Rezoning Transportation Analysis

Petition Number: 2024-037

Date	Description
4-24-24	First Review (JT)
4-24-24	Second Review (TM)
08-22-24	Third Review (TM)

**SCHEMATIC  
SITE PLAN**

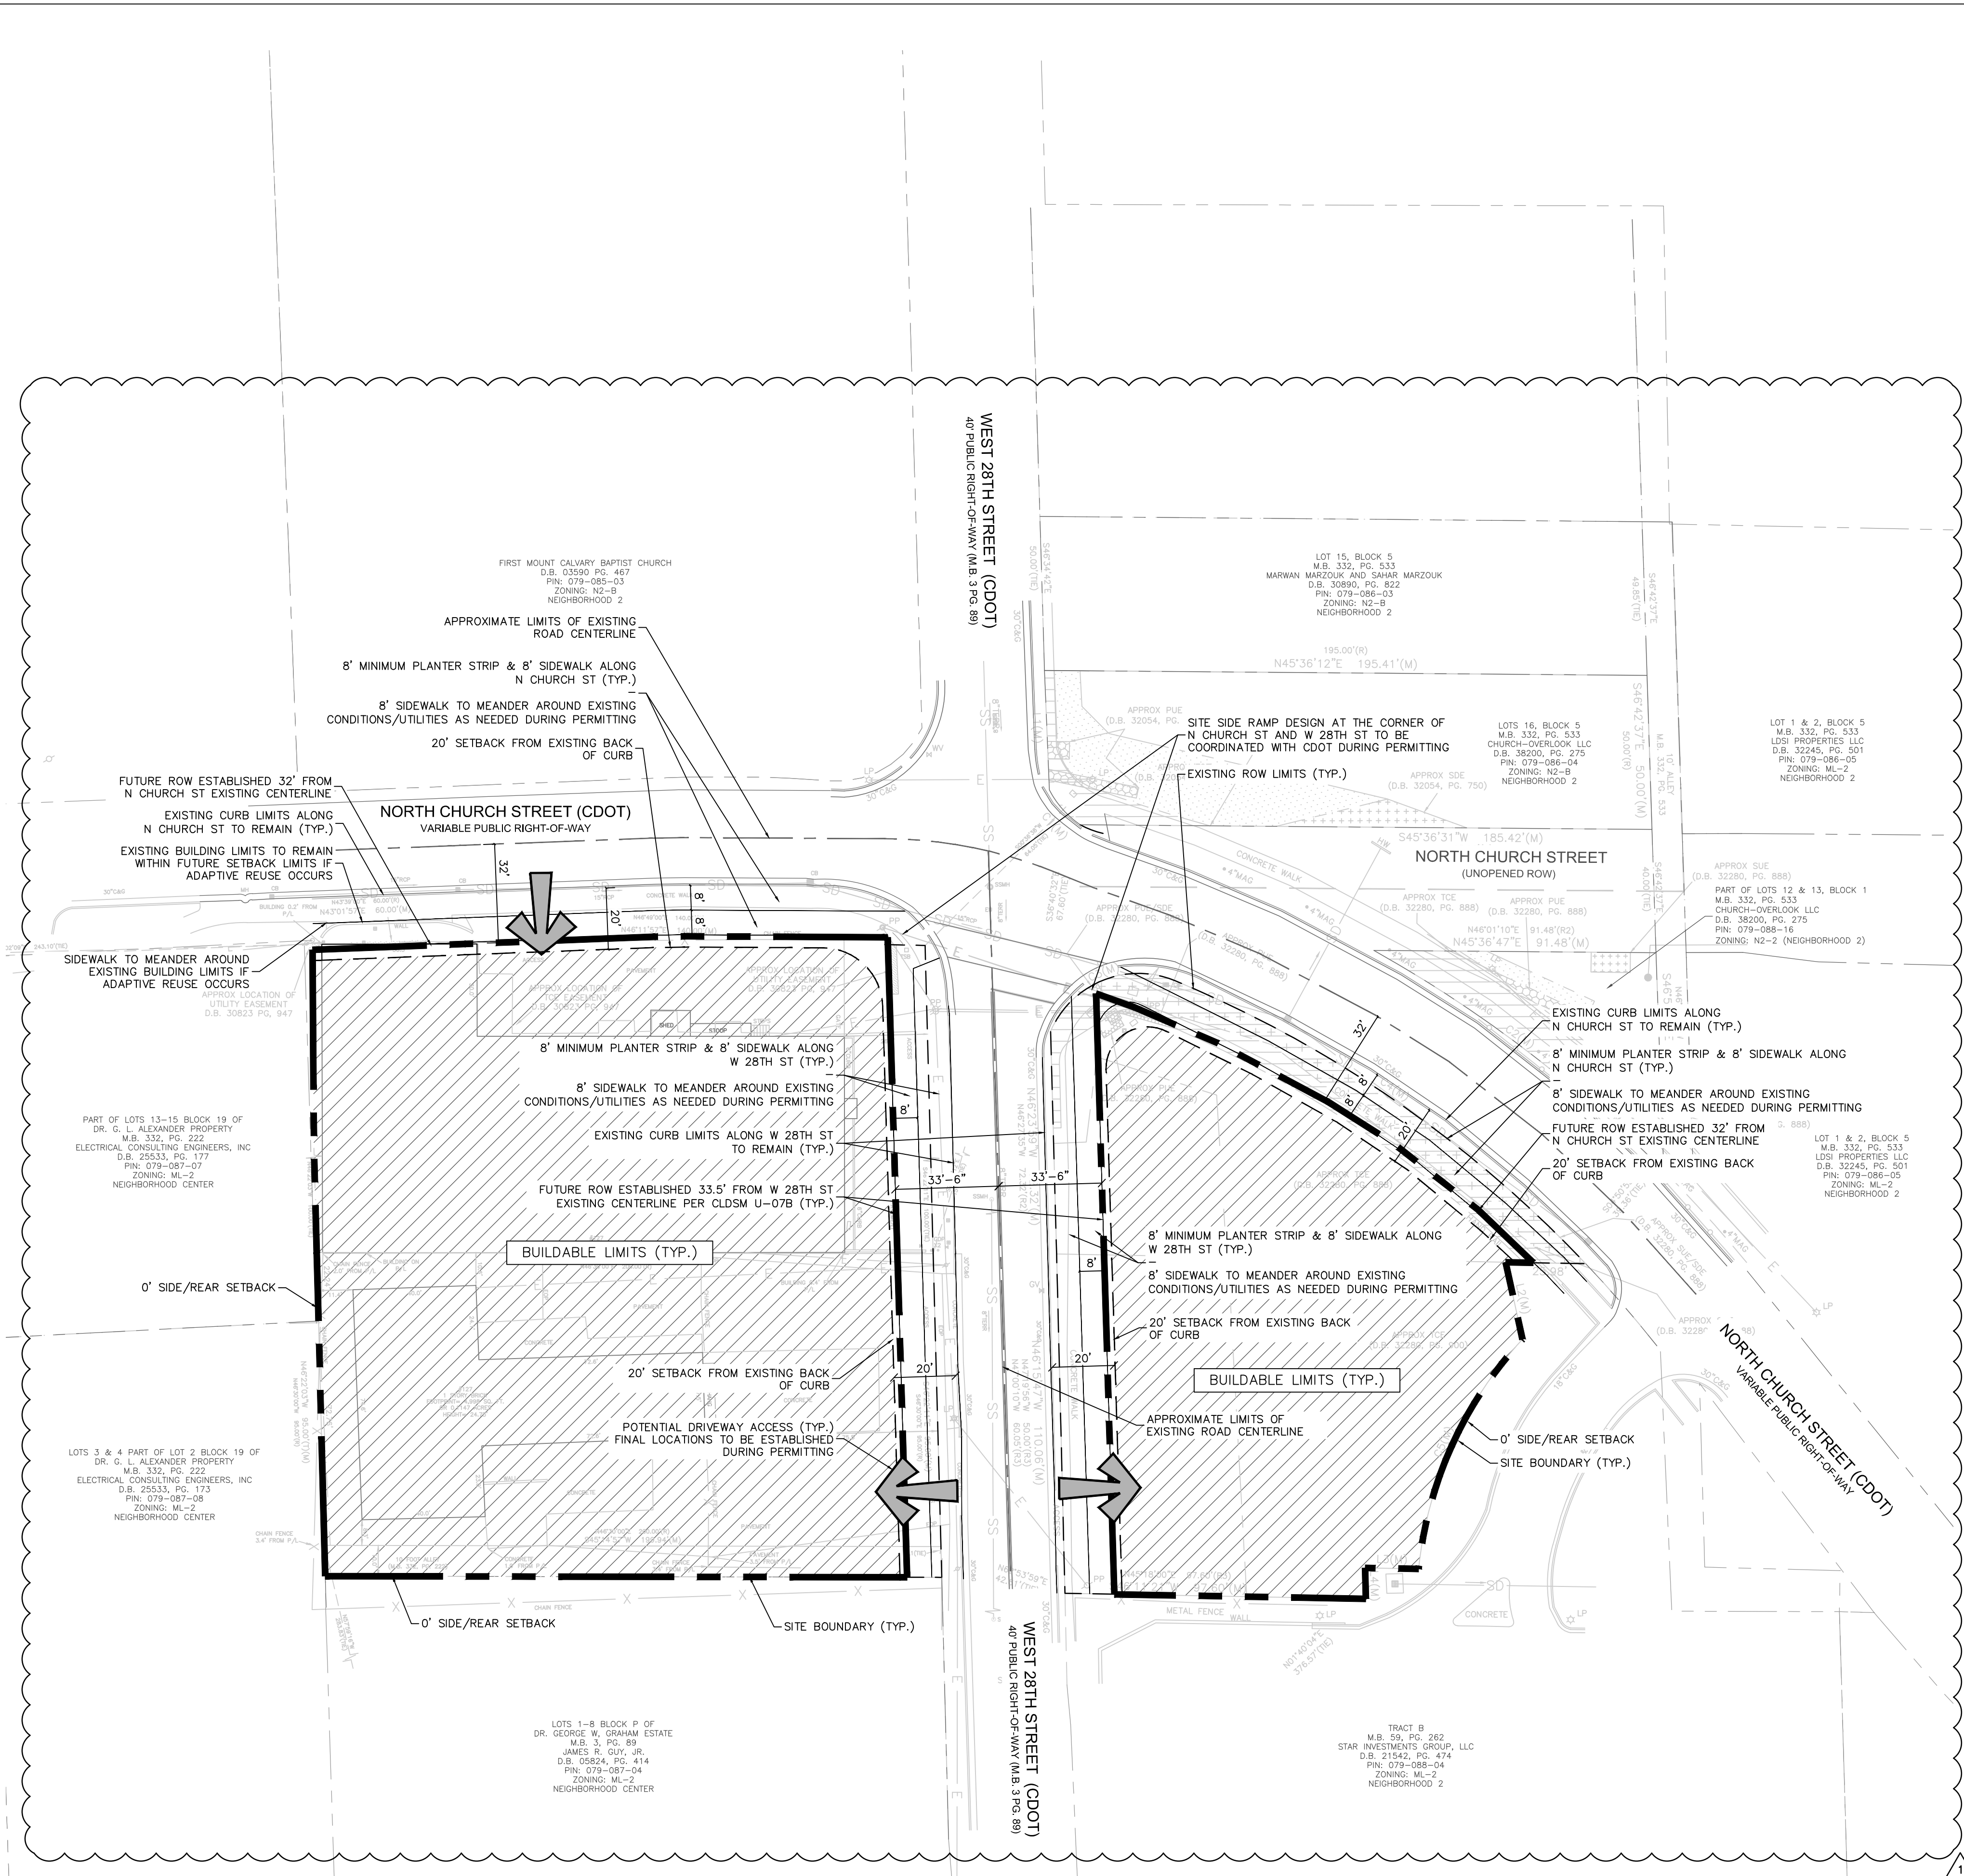
- a. ~~Church Street: The future location of curb and gutter is in its existing location.~~
